# Charlotte Department of Transportation

## Memorandum

**Subject:** Rezoning Petition 08-128: Located on the west side of Statesville Road  
between Twin Lakes Parkway and Future I-485

C1.0

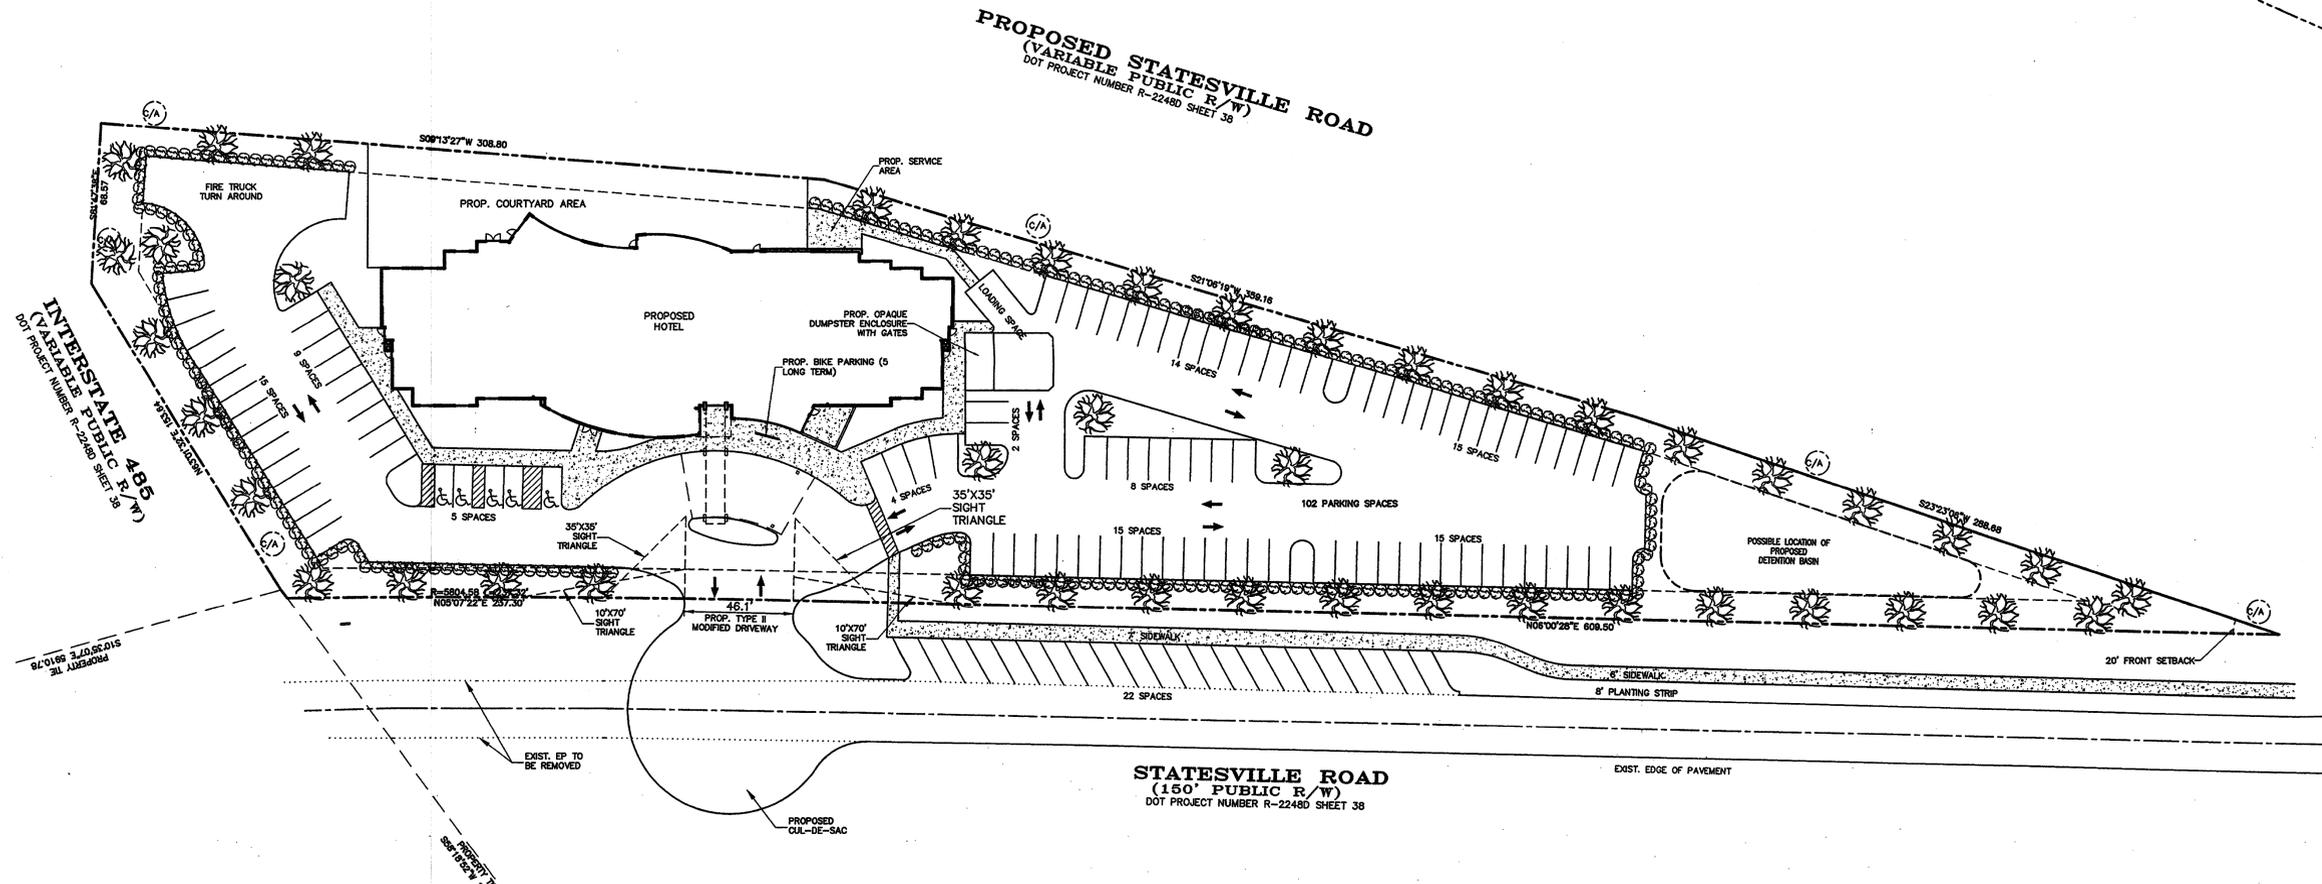
1. The developer needs to construct 5-foot sidewalks and 8-foot planting strips along the newly created dead-end street following the former alignment of Statesville Road.
2. A turnaround in the public right-of-way in the form of a cul-de-sac needs to be provided at the end of the existing old alignment of Statesville Road as shown on the site plan. If this has not been completed by the North Carolina Department of Transportation, it will be required as a condition of this rezoning petition. The access to the site will be a driveway off this permanently dead-ended street.

3. The developer needs to construct a 10-foot width multi-use path running a minimum of 25-feet outside the right-of-way of and parallel to the new alignment of Statesville Road.

1. The developer needs to construct 5-foot minimum internal sidewalks connecting all primary entrances with requested sidewalk along the newly created dead-end street following the former alignment of Statesville Road.

Adequate sight triangles must be reserved at the existing/proposed street entrance(s). Two 35' x 35' and two 10' x 70' sight triangles are required for the entrance(s) to meet requirements. All proposed trees, berms, walls, fences, and/or identification signs must not interfere with sight distance at the entrance(s). Such items should be identified on the site plan.

To facilitate building permit/driveway permit review and approval, the site plan must be revised to include the following:

- Meet applicable Land Development Standards (latest revision).
- Dimension width of the existing and proposed driveways.

- New/reconstructed driveways must be drop curb Type II-Modified driveways.
- Indicate the locations and widths of all adjacent and opposing driveways.
- Indicate typical parking module dimensions.
- Include a parking summary with figures for the numbers of parking spaces required and provided.
- Directional wheelchair ramps (two per corner) should be provided at all intersections of public and private streets.
